**Quorn Park Solar Farm (SSD-9097)  
Request for Additional Information**

I refer to the assessment of the Quorn Park Solar Farm (SSD-9097). After careful consideration, the Department is requesting that you provide additional information addressing the items detailed below:

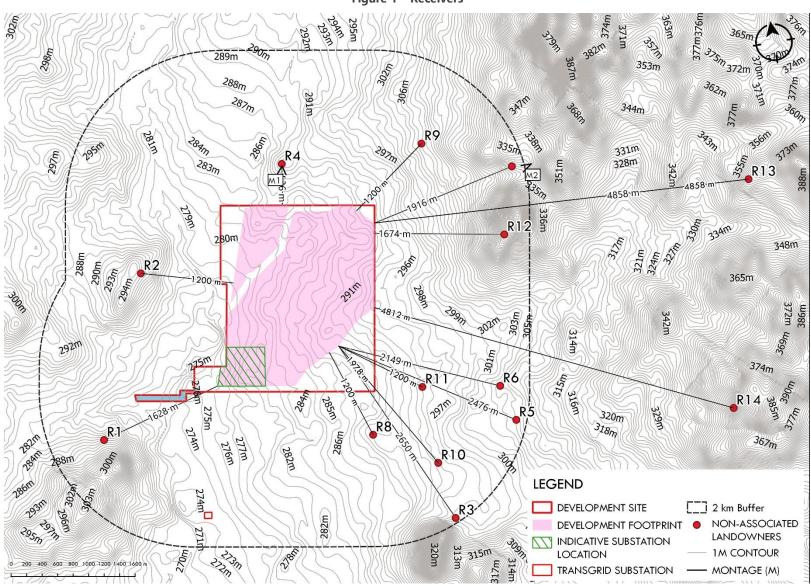
- Visual: provide further assessment detailing how the proposal has considered the full extent of visual impacts on all potentially impacted non-associated receivers including:

- a clear description of the impacts on each receiver;
  - consideration of all elements of the project (including solar panels, on-site substation, inverters, transmission lines, battery storage etc) and the full extent of the project (noting that it appears the visual assessment figures and photomontages consider a smaller layout than that proposed); and

- detail of the proposed measures to mitigate the potential visual impacts on receivers.
- Surface Water: provide additional information regarding the potential impacts of the project on downstream flows and flooding, particularly regarding the infrastructure proposed in the south-western portion of the site (including the on-site substation), including measures proposed at all stages of the development to mitigate and manage surface water runoff.
